Charlotte Storm Water
600 East Fourth Street
Charlotte, N C 28202-2844

Rezoning Petition Review

Date of Review: October 29, 2020 (***Revised December 28, 2020***)

Rezoning Petition #: 20-134

RZ-1.0

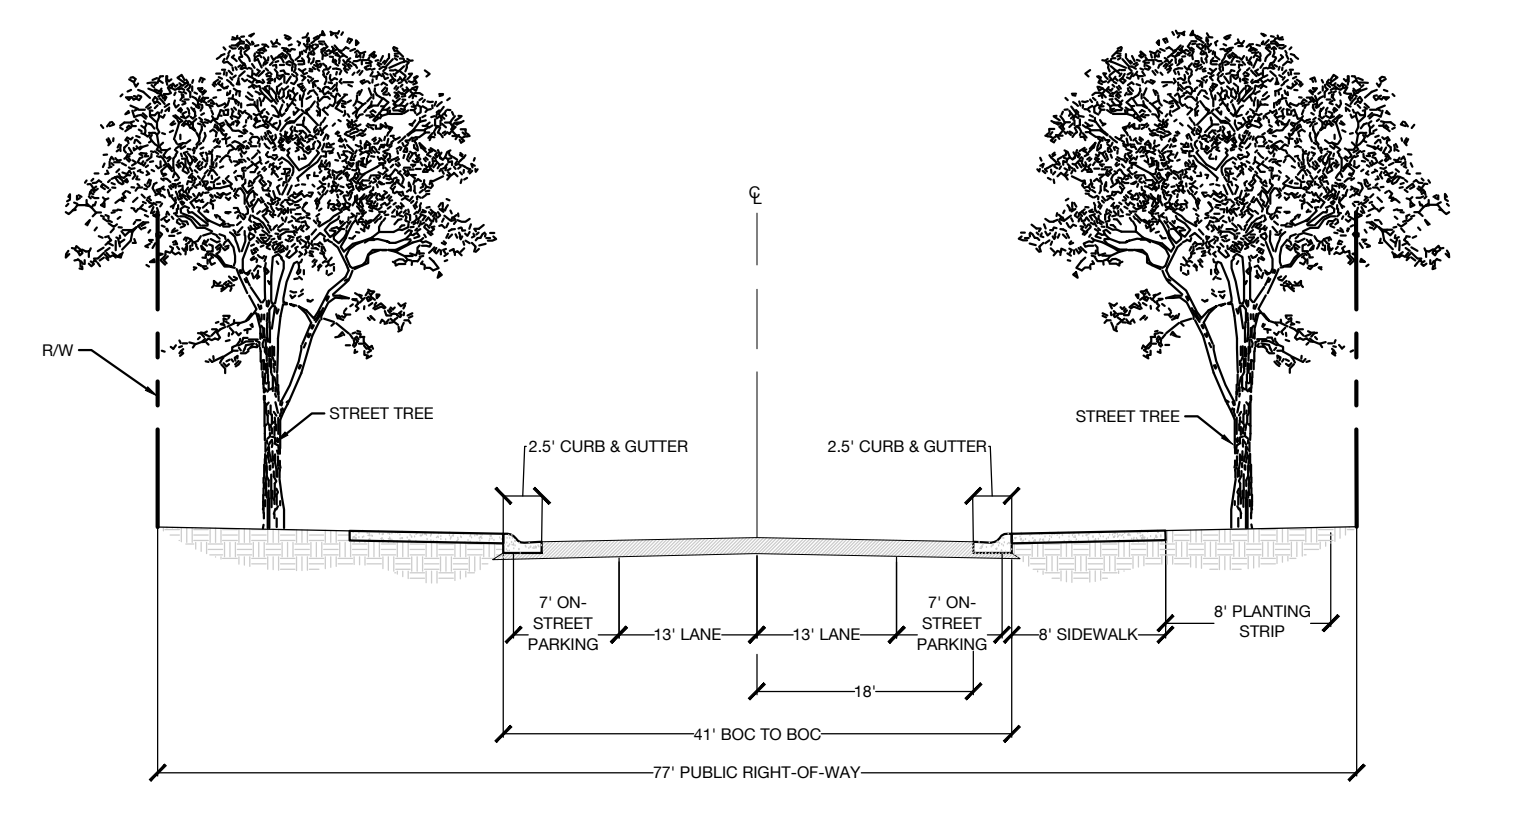
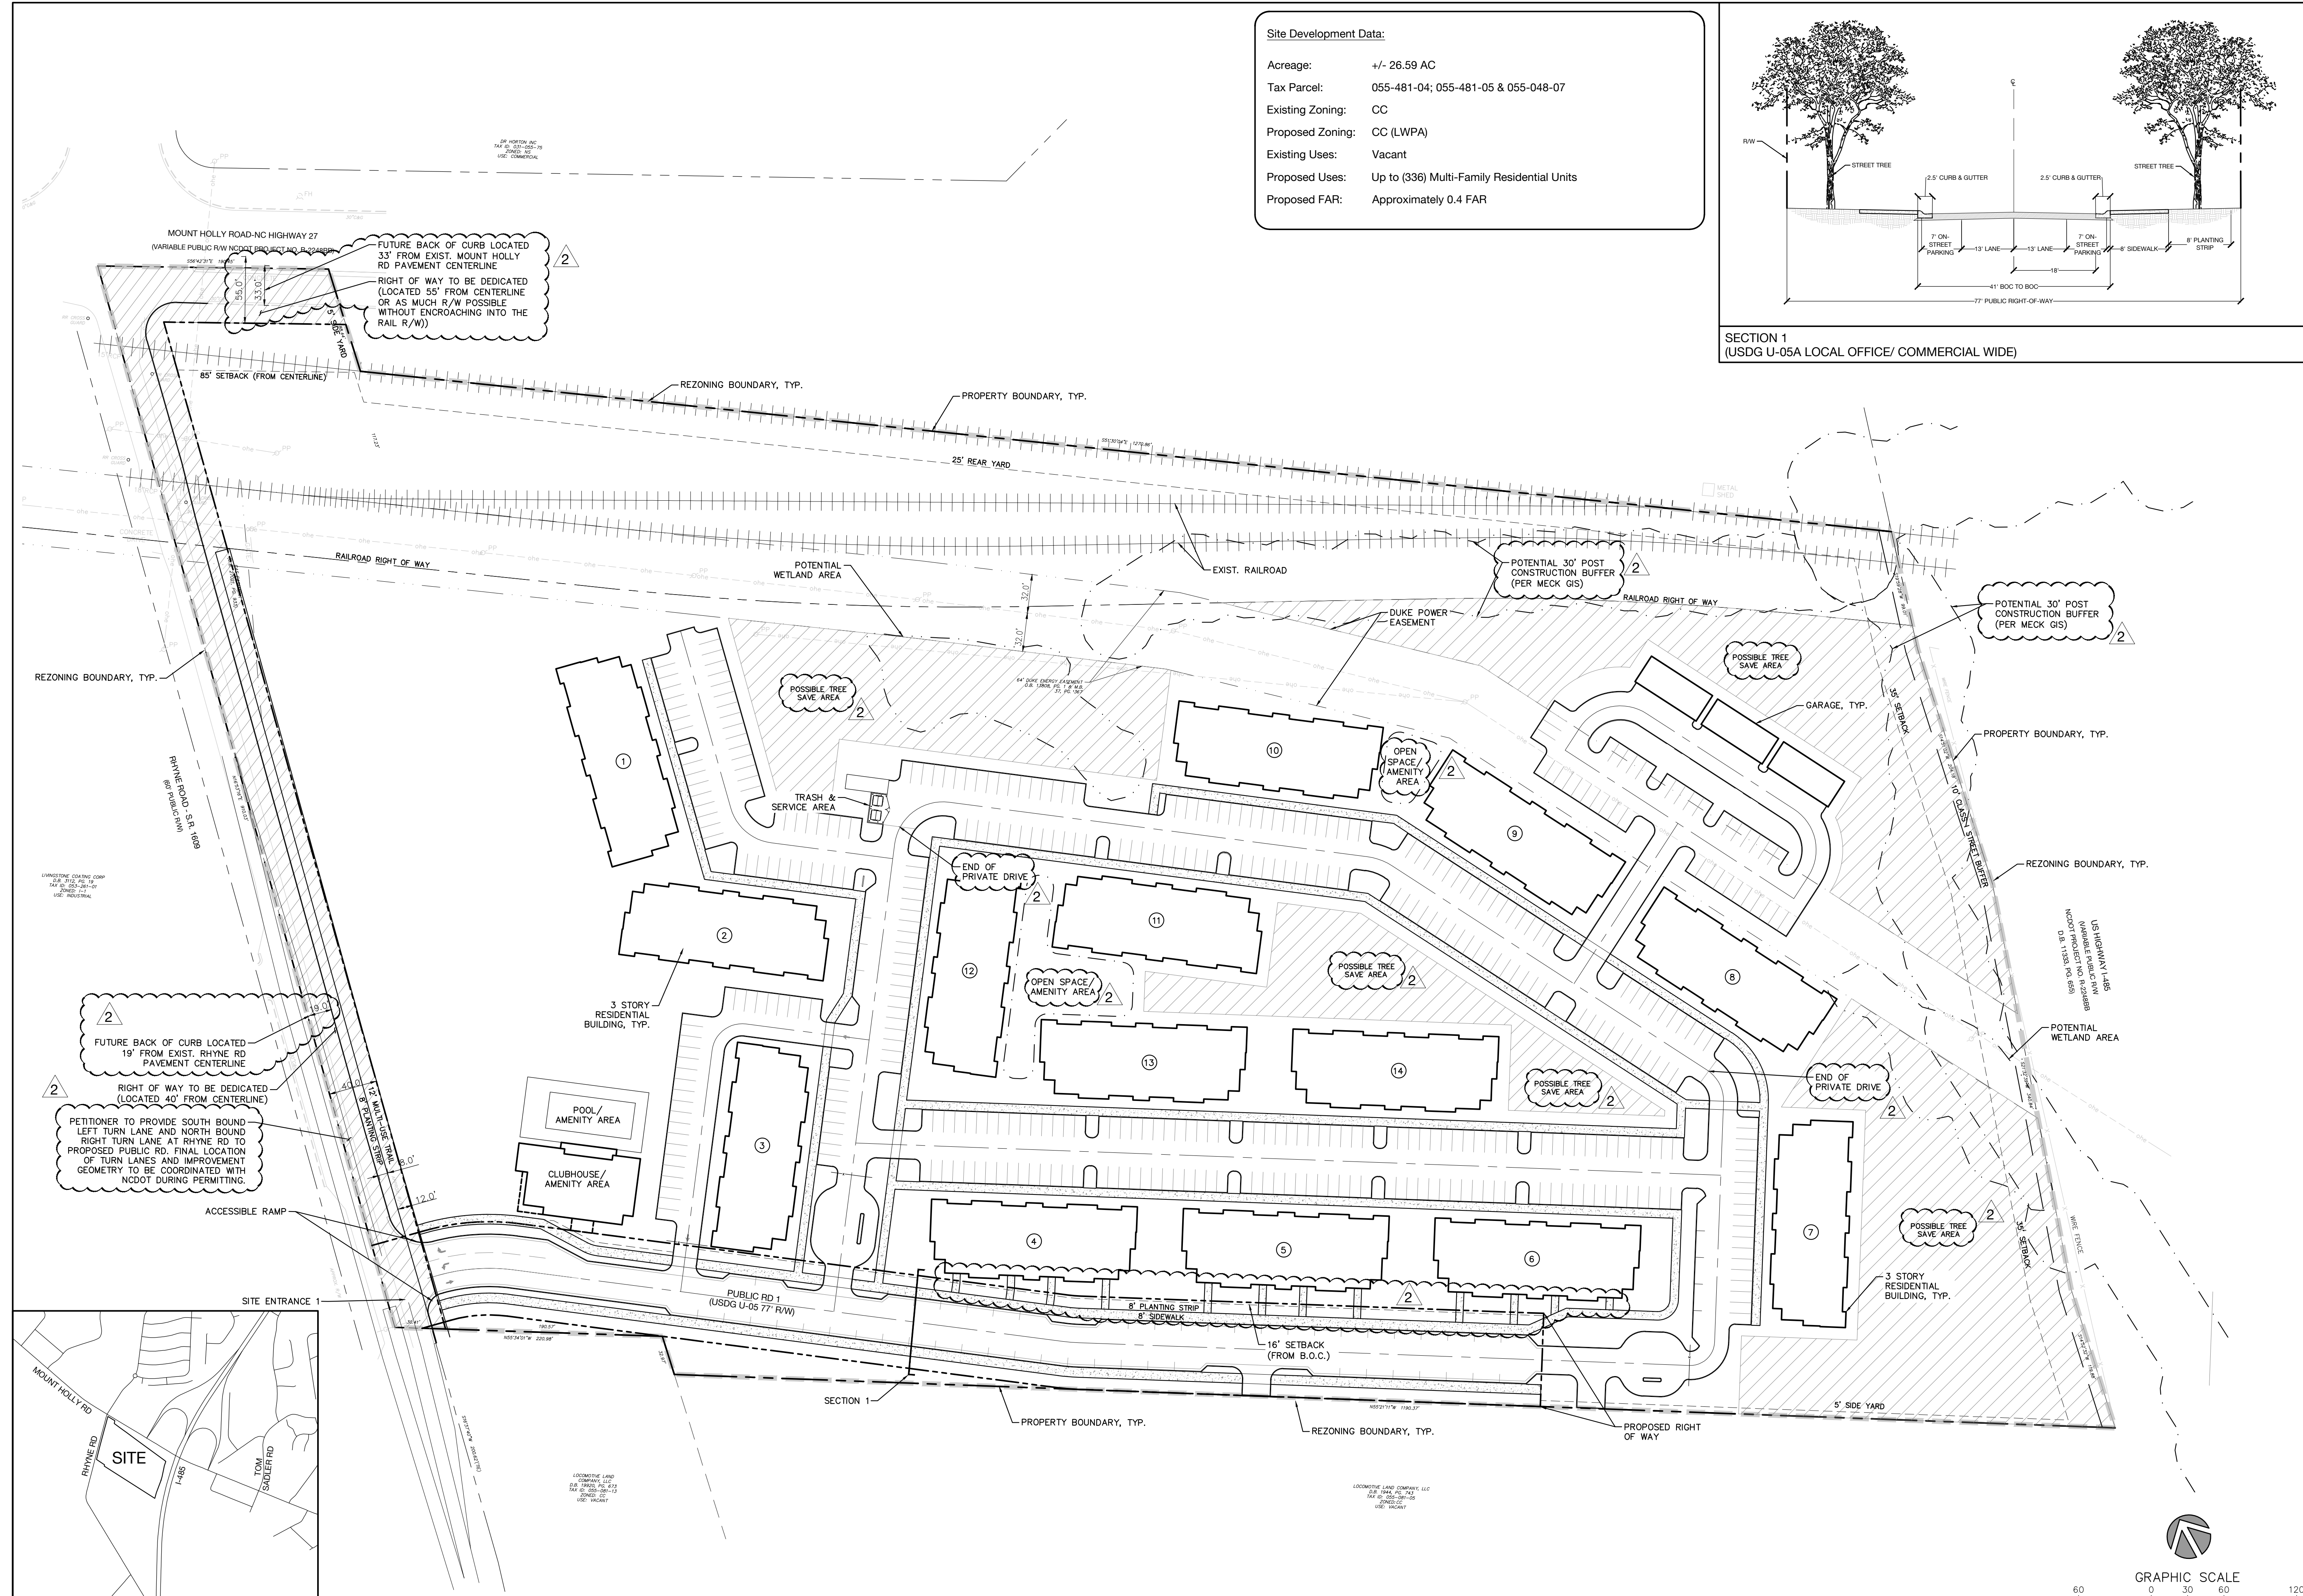
Due to revisions (11/30/20): City of Charlotte GIS data indicates a 30-ft PCSO buffer across the northern and eastern property lines of the site. Please show and label *Potential 30-ft PCSO Buffer* on the site plan. Any increase of impervious area within such buffers may not be allowed and is not approved with the rezoning process. Stream Delineation Reports are subject to review and approval by Charlotte Storm Water Services. Please include the following note under Environmental Features: *“Development within any SWIM/PCSO Buffer shall be coordinated with and subject to approval by Charlotte-Mecklenburg Storm Water Services and mitigated if required by City ordinance. Petitioner acknowledges intermittent/perennial stream delineation reports are subject to review and approval upon submission of development plans for permitting and are not approved with rezoning decisions.”*
